28<sup>th</sup> September 2023

**Supplementary objection to Application 2023/91280:**

BROMLEY FARM QUARRY, BARNSLEY ROAD, UPPER CUMBERWORTH, HUDDERSFIELD, HD8 8PD  
QUARRYING OPERATIONS FOR THE EXTRACTION OF CLAY, SHALE AND INCIDENTAL COAL AND  
SUBSEQUENT RESTORATION BY MEANS OF IMPORTATION OF INERT WASTES

ACCESS POINT DETAILS

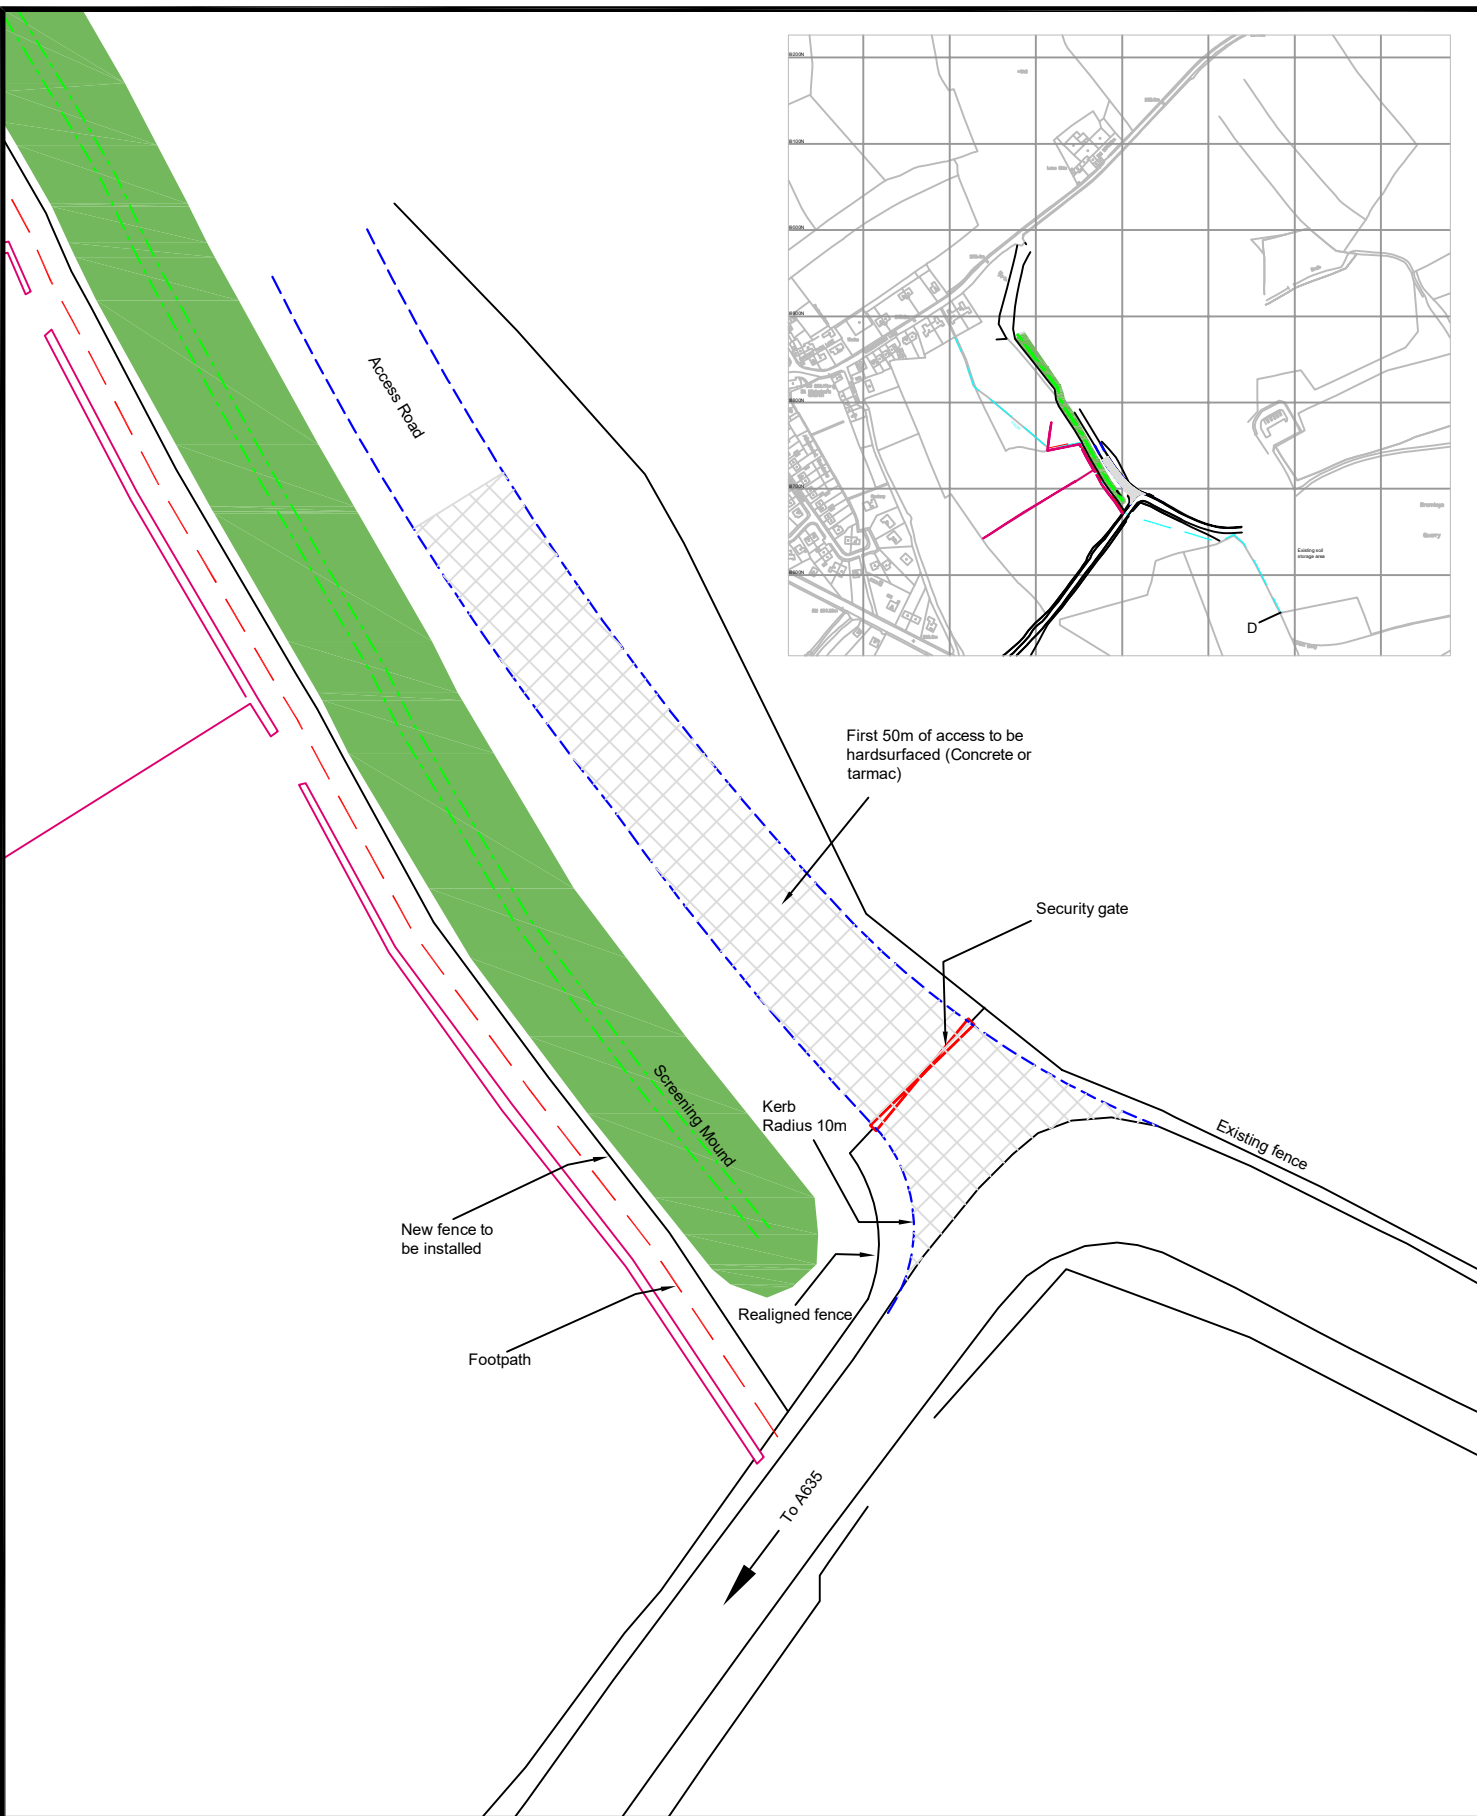
- The assessment shows completely unrepresentative photographs that do not show the reality of the A635 and its associated traffic.
- Where is the data on peak traffic flows referred to in paragraph 2.1.4?
- There is no route traffic assessment included
- Crash map data have proved unreliable for this area for years and do not reflect local experience as previously discussed during the Local Plan hearings.
- We would draw your attention to **Appendix 1** and the accident highlighted and to the fact that the journey will involve both the Sovereign cross-roads and Penistone Road junctions which have been the subject of internal council reports because of Safety issues.
- The report fails to consider parking on the A635 opposite the Bromley Park entrance, which would seriously impact on the right turn HGVs would make. This is illustrated in Photograph 1 below.

- There is no assessment of traffic using the recycling site and the impact these movements will have on the operation of that facility.
- This proposal is in direct contravention of **LP 21**, failing to take into account the features of the surrounding roads and footpaths and provide adequate layout and visibility to allow the development to be accessed safely. We would remind the LPA that Carr Hill Road has no footpath for much of its length and that this potentially endangers the safety of road users. You have been given photographic evidence that quarrying vehicles are using this route and are in breach of Highways code 163.
- **LP36 Part 2** - It will prejudice highway safety through the volume and nature of vehicle movements generated, particularly when cumulative impact is considered, as is a requirement of the Local Planning Authority.
